Our Ref. CS/JP/P/S/2

18th June 2025

Re: H16-0515-25 (Full)
Residential development of 76 dwellings and associated infrastructure
Land at Horseshoe Road, Spalding, PE11 3JB
Seagate Homes (UK) Ltd

Horseshoe Road, Spalding: Overall Masterplan. LS01 (1:500 @A1)

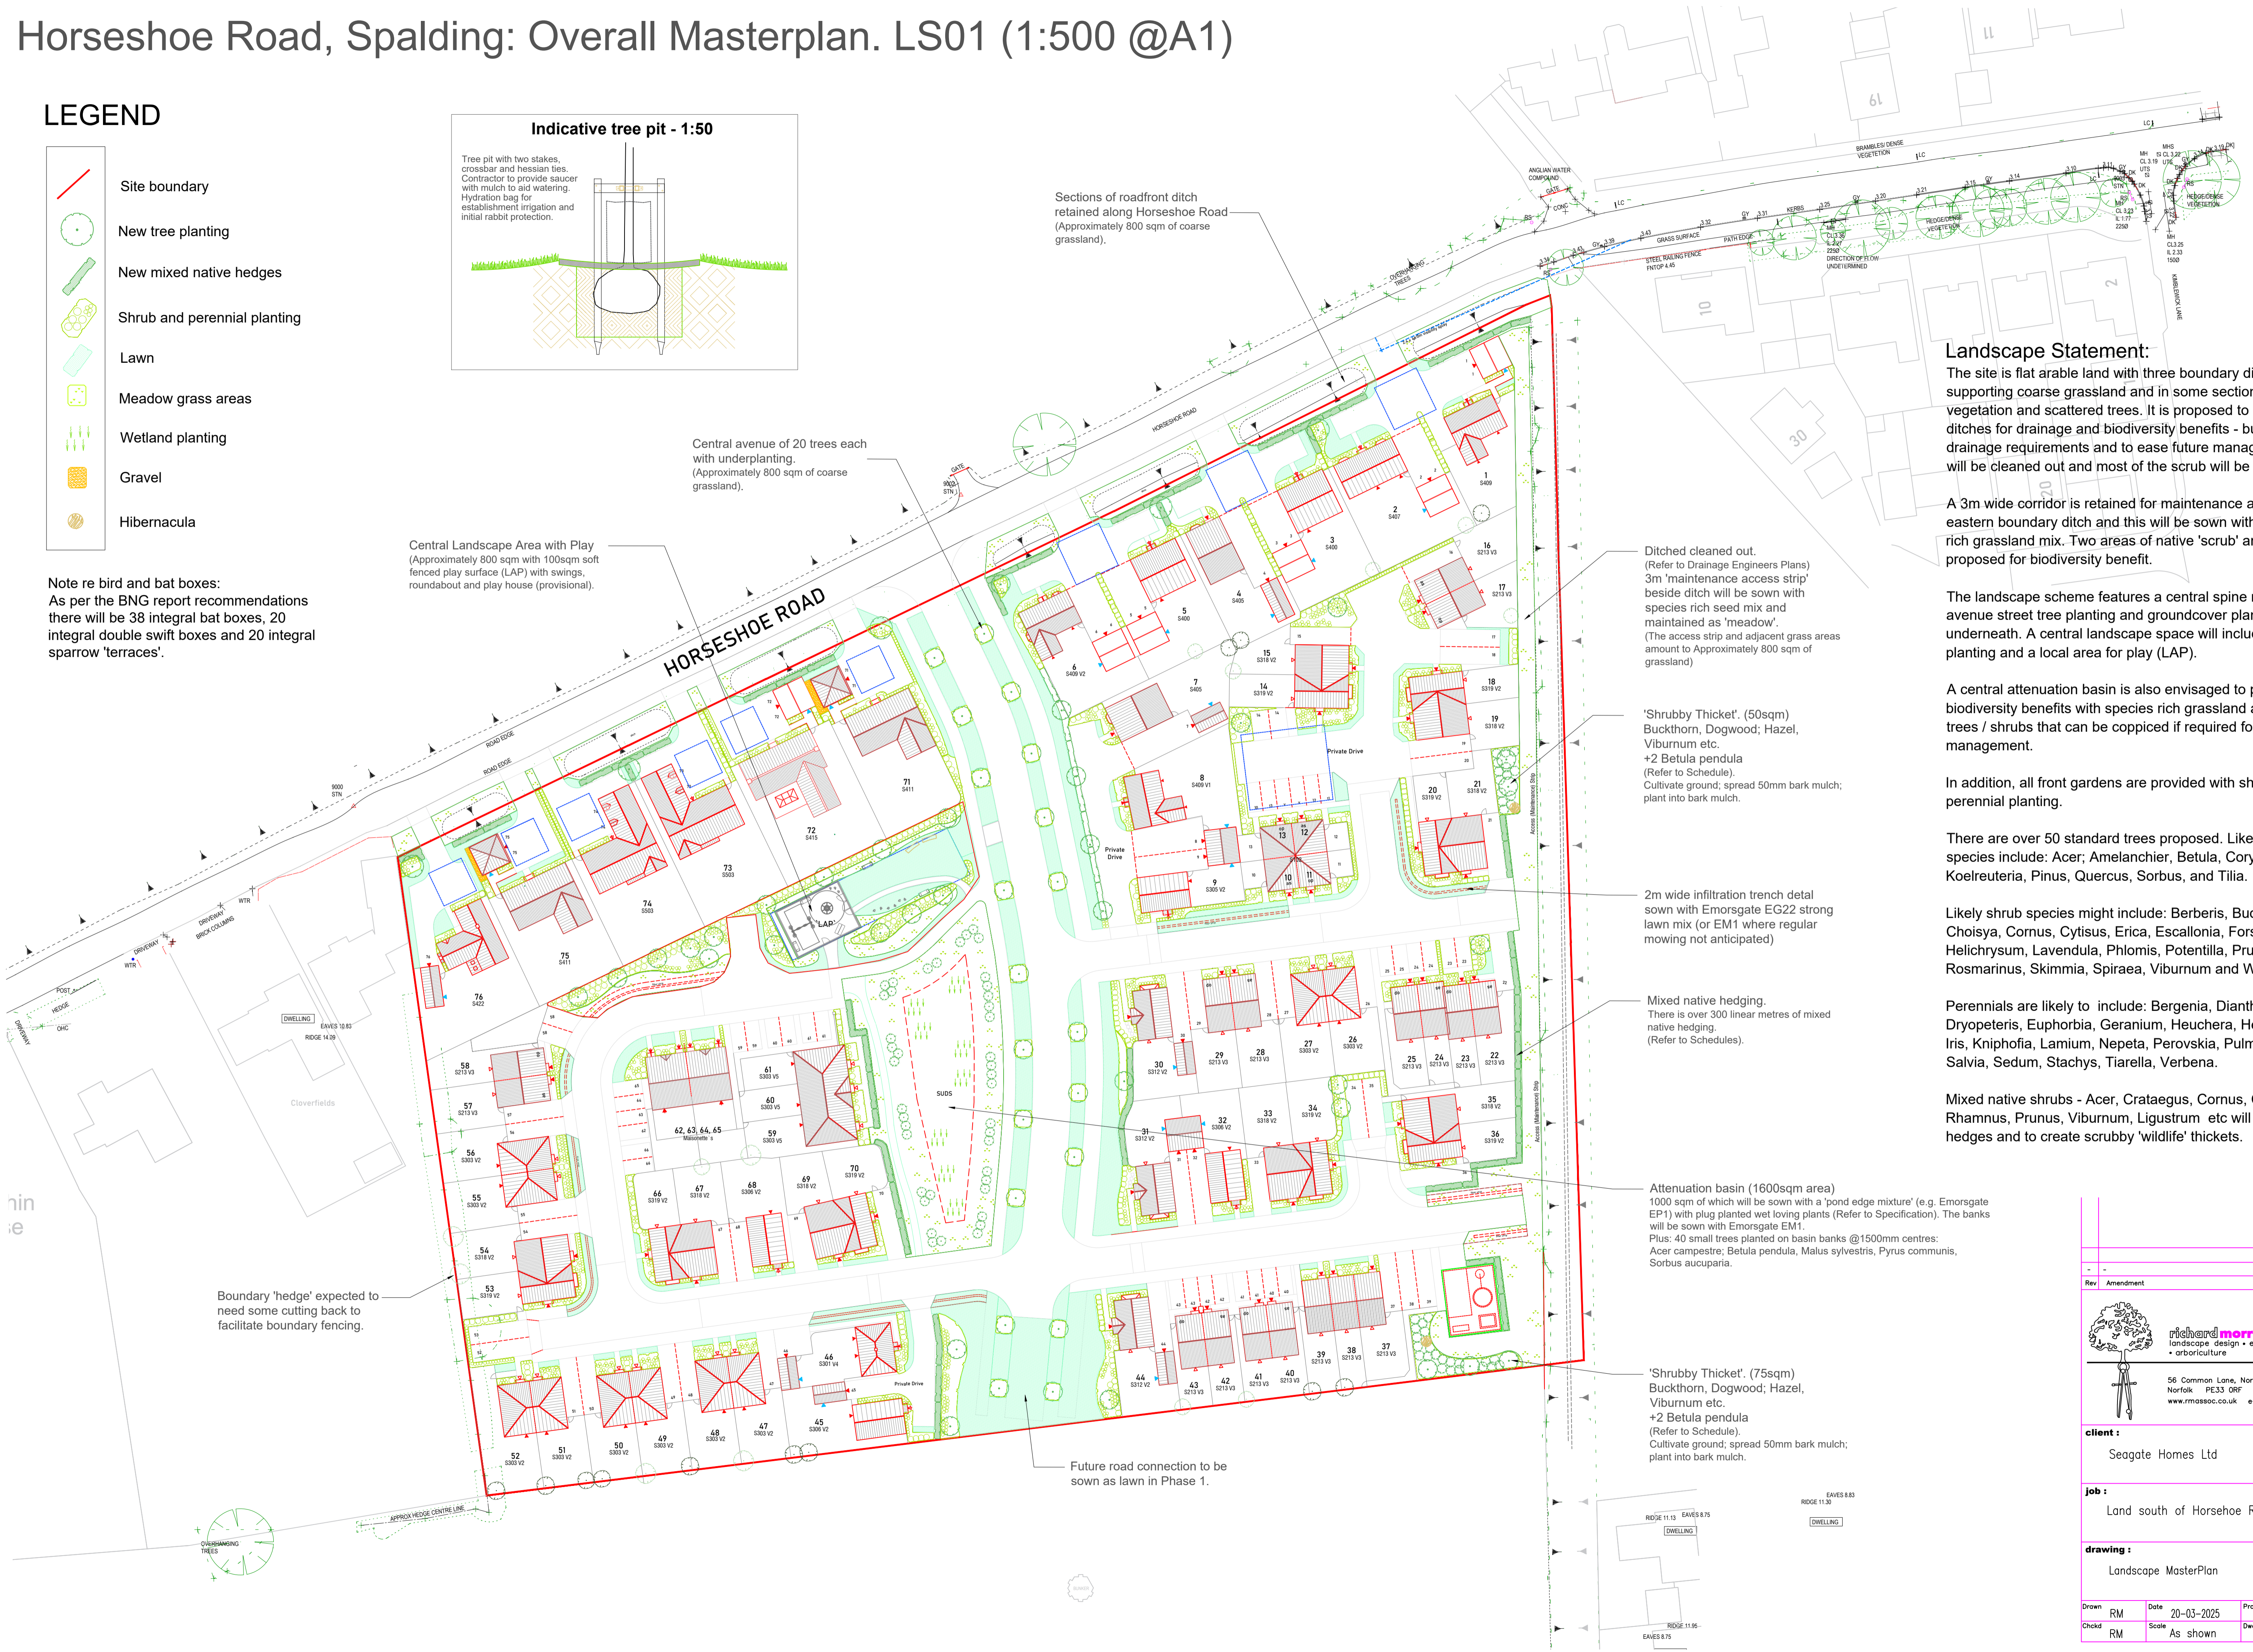
I am pleased to see that a maintenance strip has been left alongside the riparian dyke and suggest that it should be approximately four metres in width with no landscaping obstructions being placed within it to enable access for machinery.

The proposal of discharging surface water into the riparian dyke is agreeable with the Board in principle, subject to the submission of an application for consent to discharge surface water prior to connection. This watercourse may need to be cleared and improved in advance of any new surface water connection.
